SSI - 5414 - North West Rail Link EIS 2

2 Indicative Layout – Bella Vista Station Precinct

RE: McDONALD'S, BELLA VISTA

Figure 6.28 Bella Vista Station - Indicative vehicle and pedestrian movements

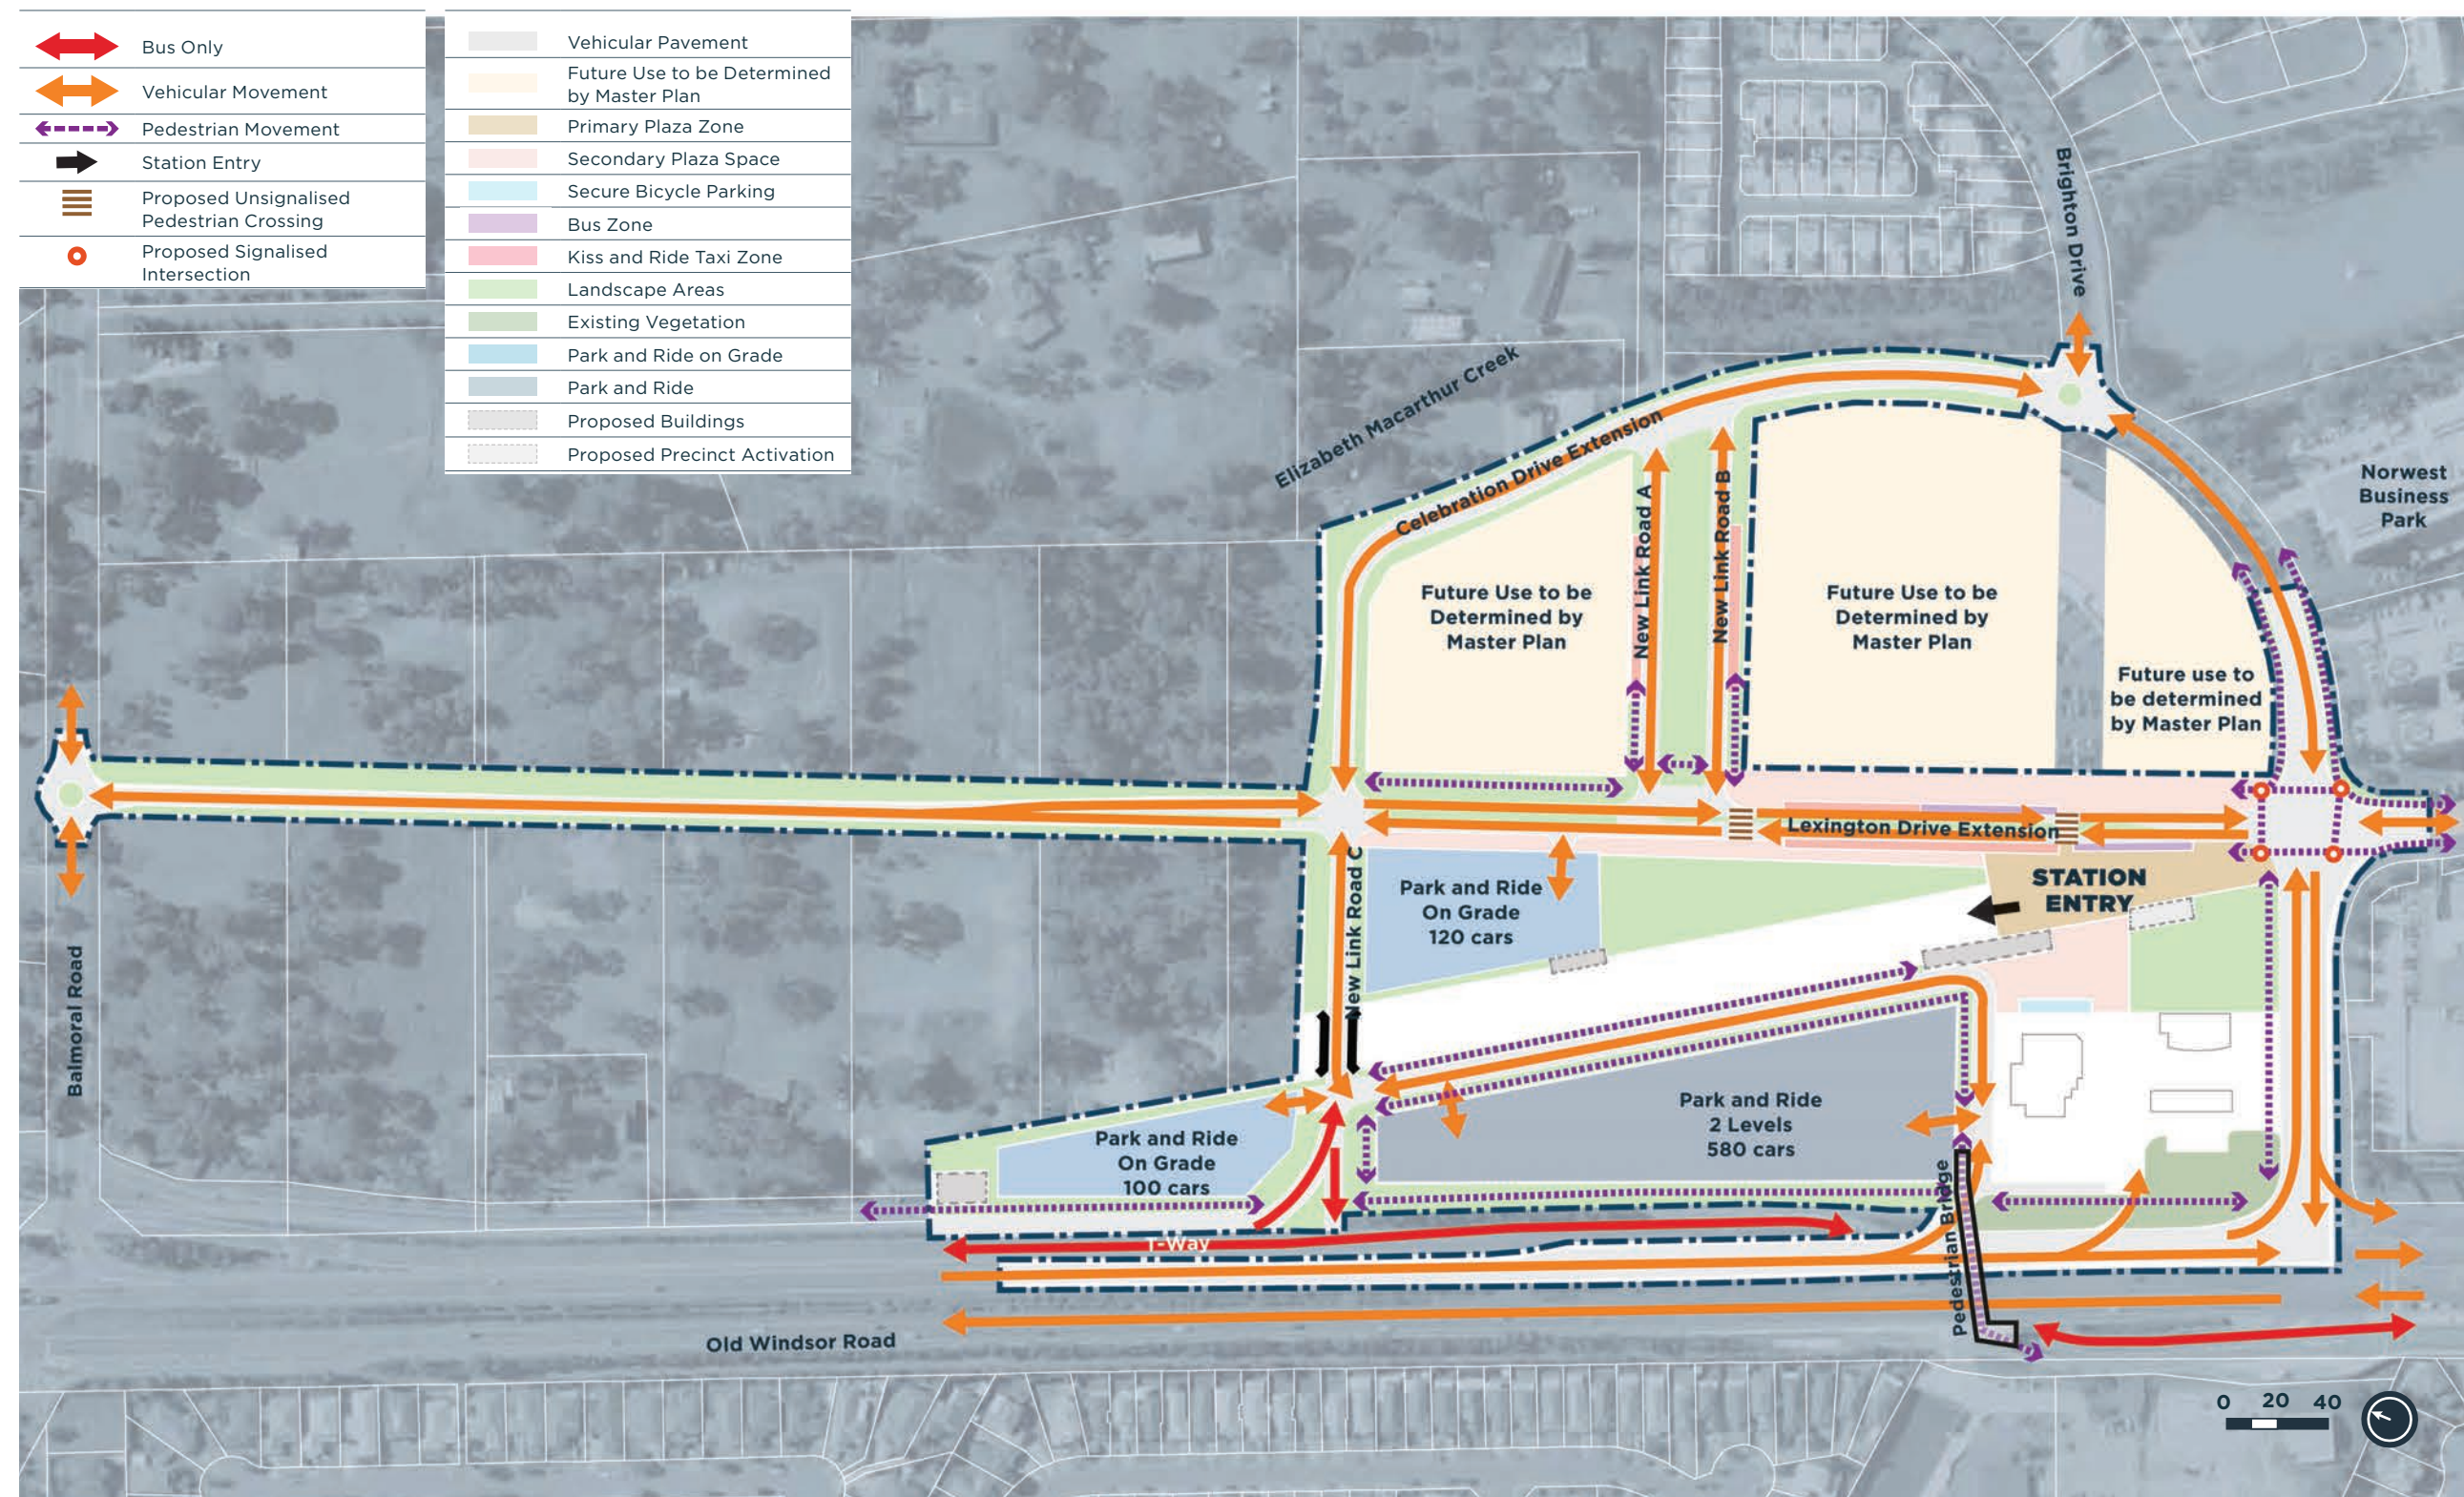
6. The construction of the proposed station would have significant impact on access to McDonald's. The plans show no impact on the ingress from Old Windsor Road. Figure 6.28 in EIS 2 shows indicative vehicle and pedestrian movements. Due to the construction of the station the existing entry/exit to Lexington Drive (via the existing ROW though the Homemaker Centre development) would be closed. Alternative access would be provided to the north. While not shown it is assumed that the existing connection to Celebration Drive (via the adjacent BP service station) would be retained. Thus access to the site from Norwest and access from the site onto Old

Windsor Road would be severely restricted. To reach Old Windsor Road vehicles would need to use one of the following routes:

- exit onto Celebration Drive (left turn) and then turn right onto Lexington Drive and use Norwest Boulevard to access Old Windsor Road; or
 - exit onto Celebration Drive (left turn), pass through Lexington Drive and use the roundabout at Brighton Drive to undertake a u-turn and then travel back along Celebration Drive onto Old Windsor Road; or
 - travel north from the site, around the station and use either the Celebration Drive extension or Lexington Drive extension (through the bus interchange) to access Celebration Drive and then Old Windsor Road.
7. Each of these routes is much longer than the existing connection to Lexington Drive via the ROW through the Homemaker Centre. Thus the construction of the station would result in lower level of accessibility to Old Windsor Road and the surrounding area compared to today.
